Andrew Titmus
The Old Police House, Arundel Road,
Fontwell BN18 0SX

3rd November 2021

Application WA/88/21/DOC

Figure 2.0 – Proposed Building Specific Sound Level Map

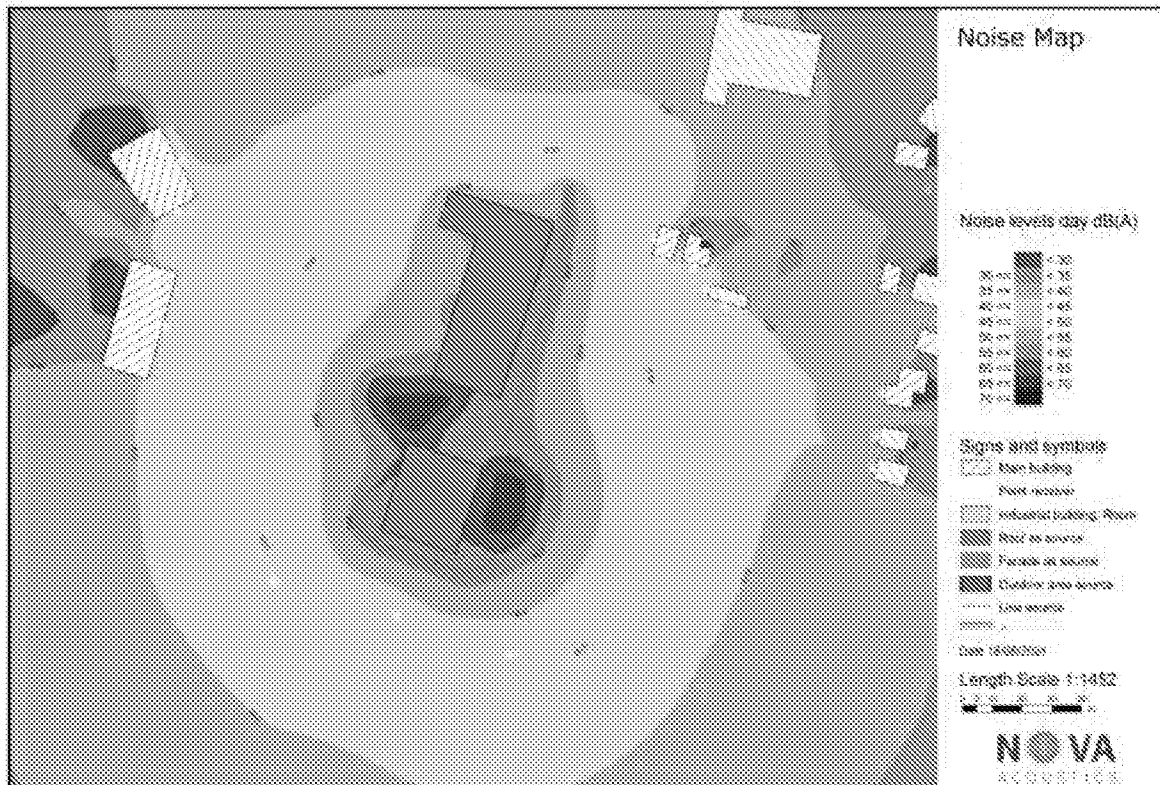
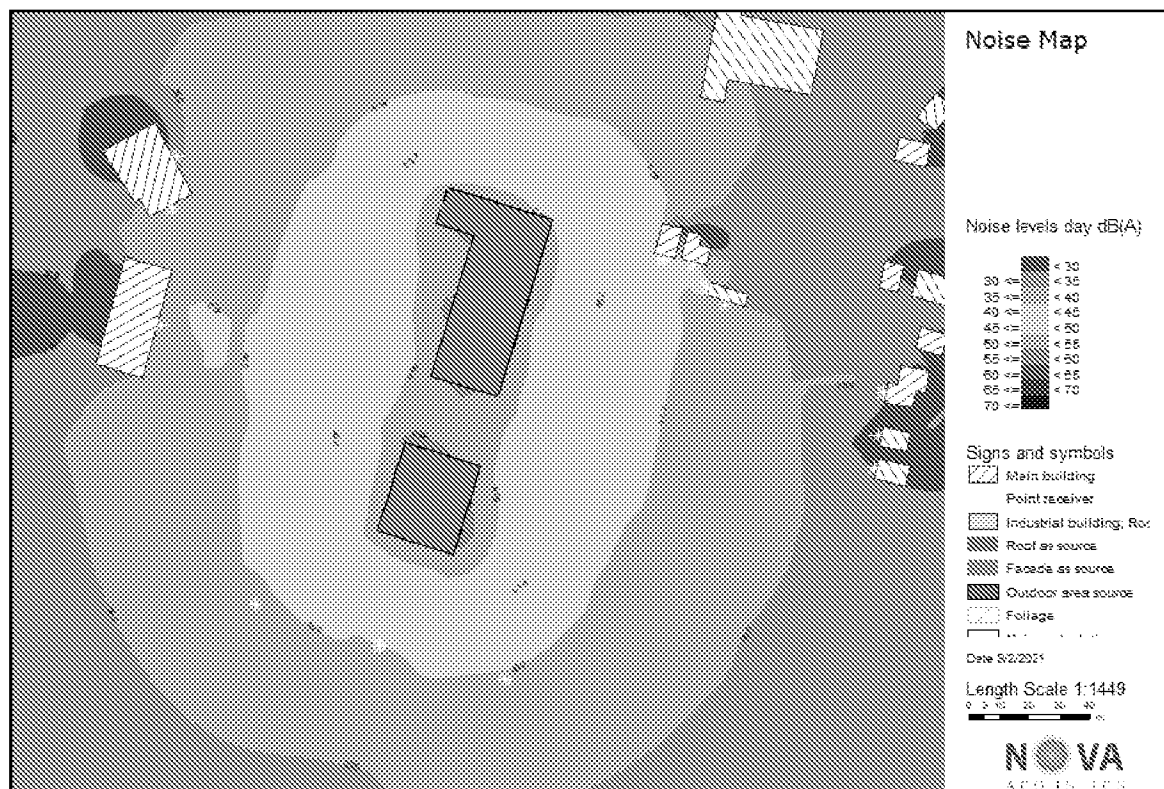
The potential for HGV reversing sirens and forklift loading, together with roller shutter doors, within meters of bedroom windows (Block J on the Dandara site being particularly close), this is undoubtedly excessive and raises a question over whether, the proposed use falls within class B1 usage where such wide timing of HGV deliveries is required. I have attached a plan overlaying the GTR site with the Dandara residential development as it is unfortunate that the applicant has not provided a visual indication of the proximity of residential property to the site; particularly the HGV turning and unloading area where there is likely to be a higher concentration of noise (notably engine and reversing sirens).

The same application similarly refers to 'optional acoustic fencing'. The application discloses a low level of background noise, particularly over night. Where there will be noise generating equipment on site, in such close proximity to bedroom windows, mitigation against noise should not be optional.

Any externally mounted noise-generating equipment, intakes and exhausts should be mounted on the side of the building not facing residential properties (the west elevation). The applicant will have refrigeration and air-handling equipment running at all hours and these should not be sited where they can cause disruption to the quiet enjoyment of residential property.
